Re: Planning Application 20/0465

Address: Land adjacent to The Beeches 65 Whalley Road Langho BB6 8EF

Description: Application for outline planning permission for the demolition of an existing garage and the erection of two detached dwellings including details of layout and access with all other matters reserved.

Illustrative Layout and Streetscape

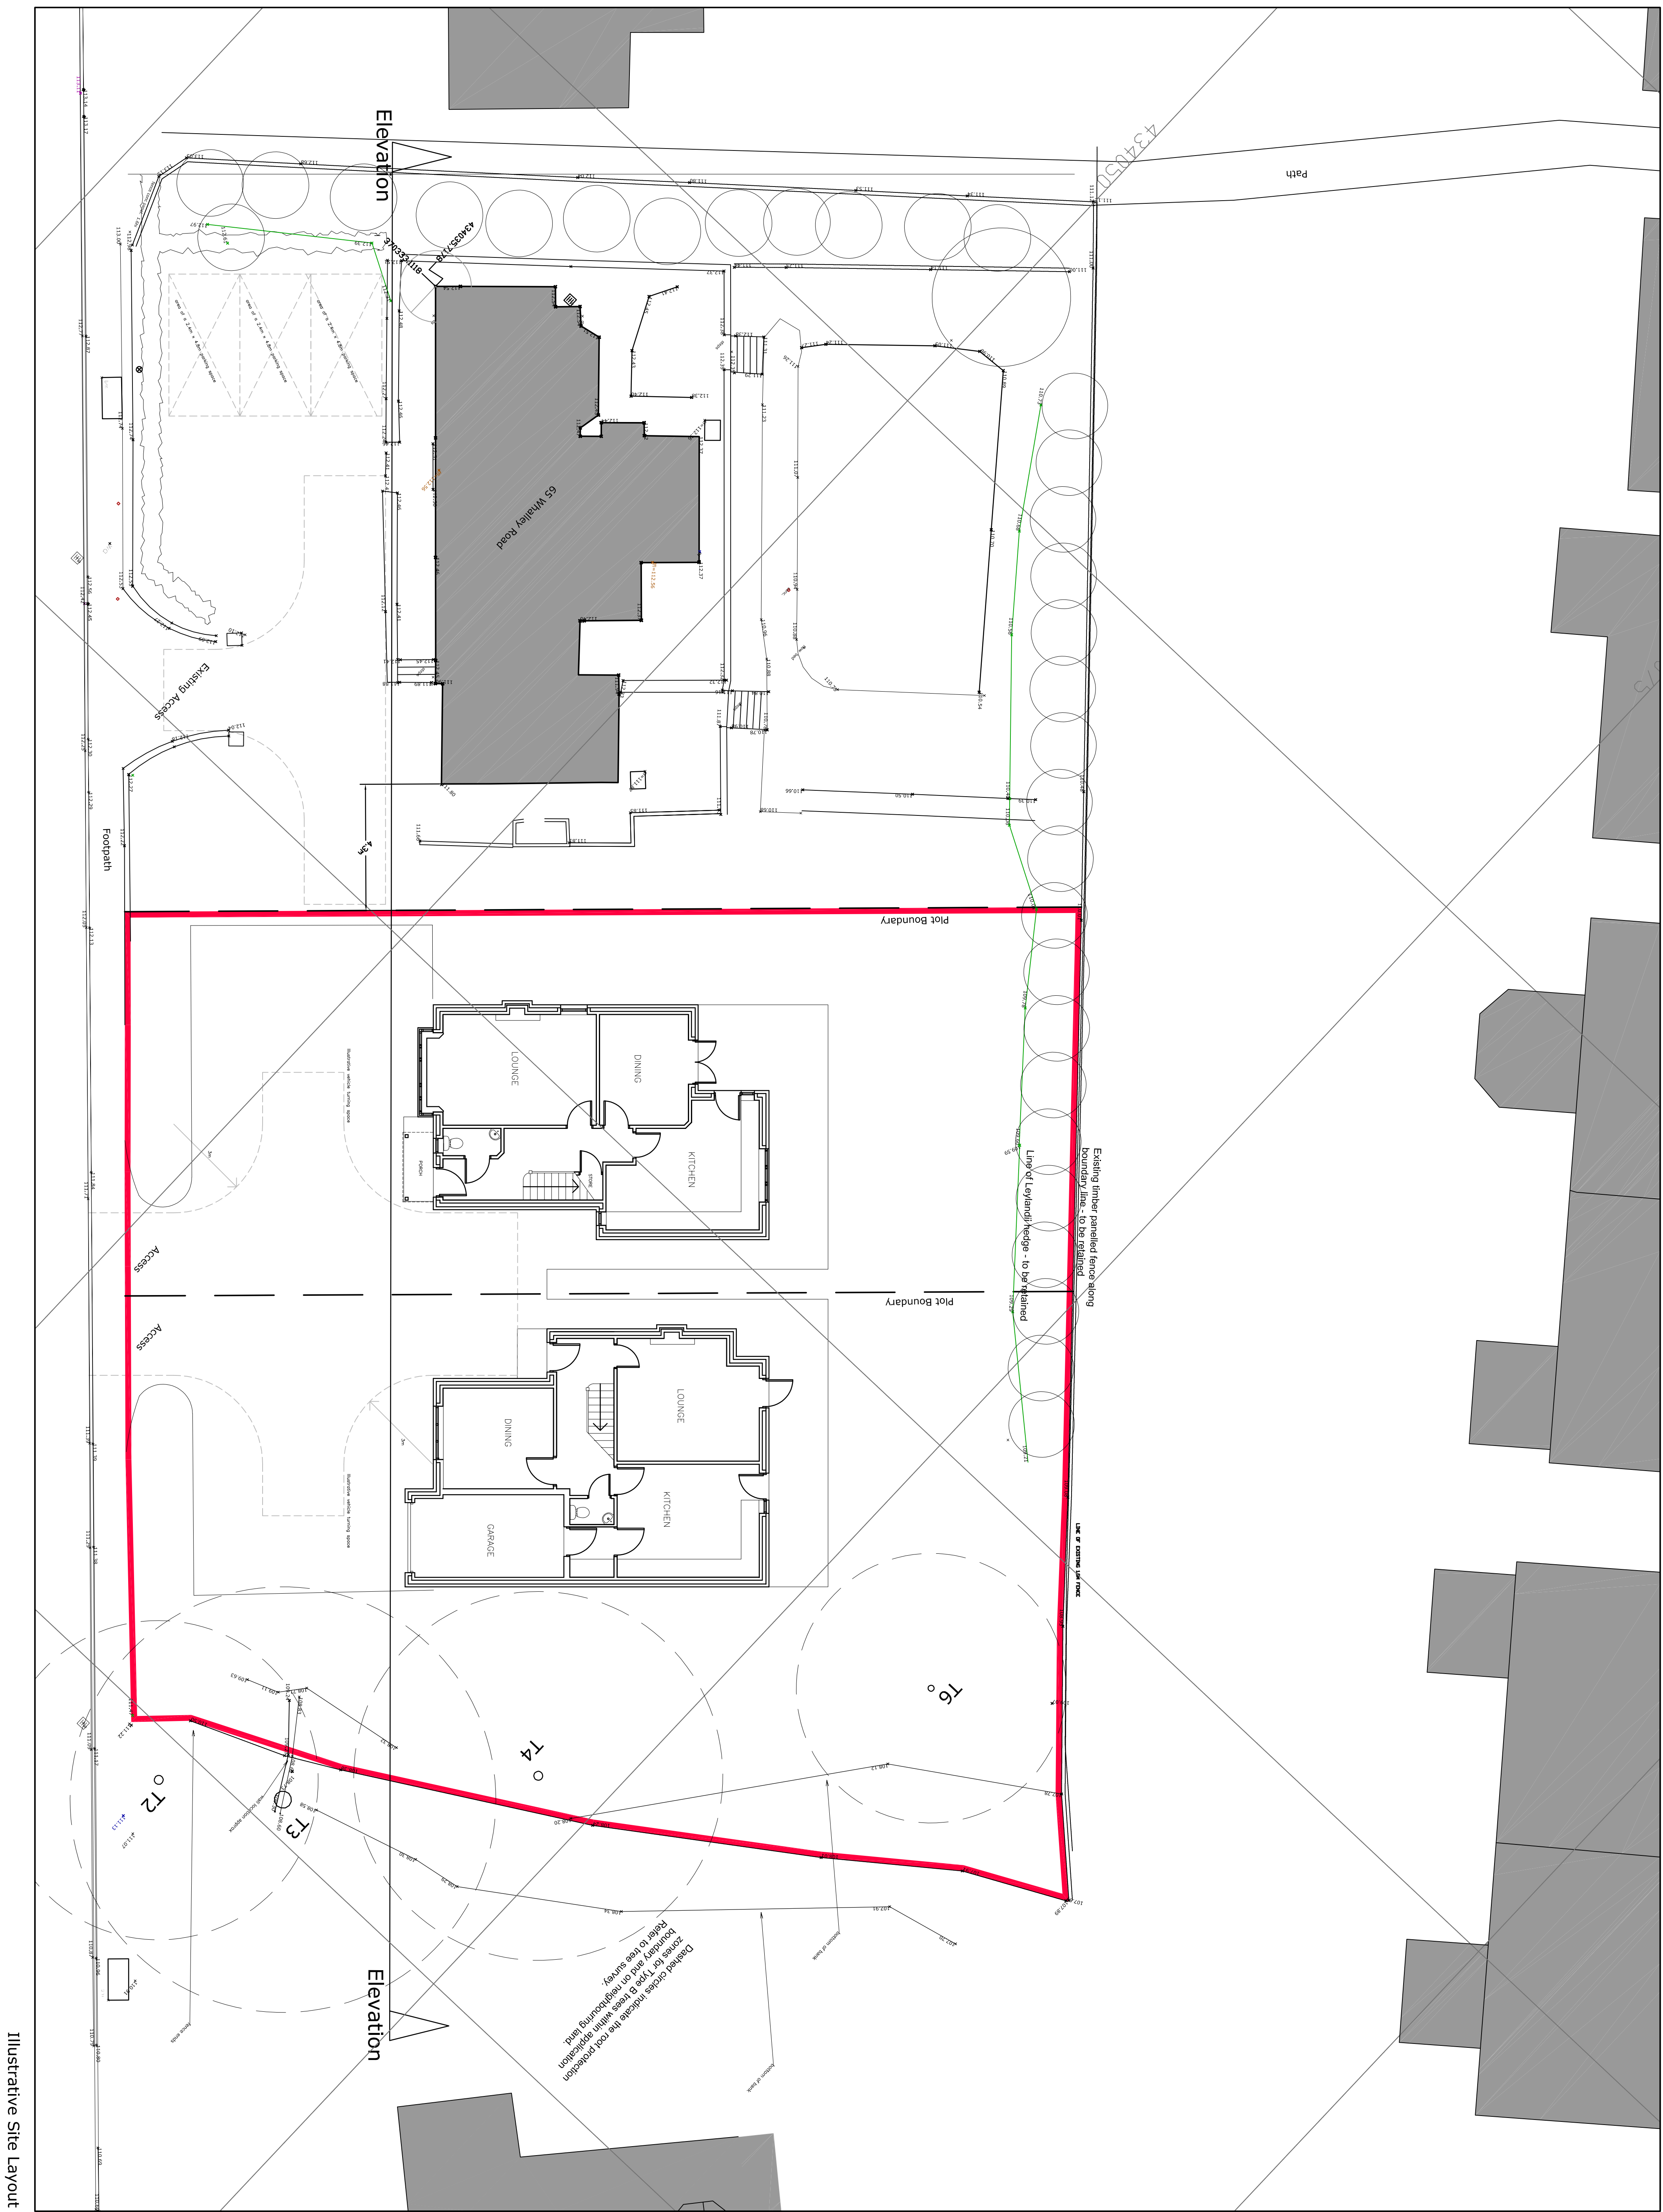
- A plan showing the Visibility Splay at 2.4m x 45m should be provided, two local traffic counts show the 85 percentile speed to be an average of 31 mph
- To accommodate any parked cars in the vicinity of the adjacent school the splay should be measured to the nearside kerb in both directions
- Anything obstacle such as a wall, hedge, tree or shrub that falls within the visibility splay should be cut down or lowered less than 1m above the centre line of the carriageway and maintained as such for the perpetuity of the development.
- The width of the access should be less than 5m the existing lower kerb may require realigning to accommodate the new access

- Each dwelling should have sufficient hard standing to accommodate 3 off street parking spaces they should measure 2.4m x 5m. The vehicles should be able to enter and exit the premises in a forward gear. A garage measuring a minimum of 3m x 6m internally is considered to be a car parking space.
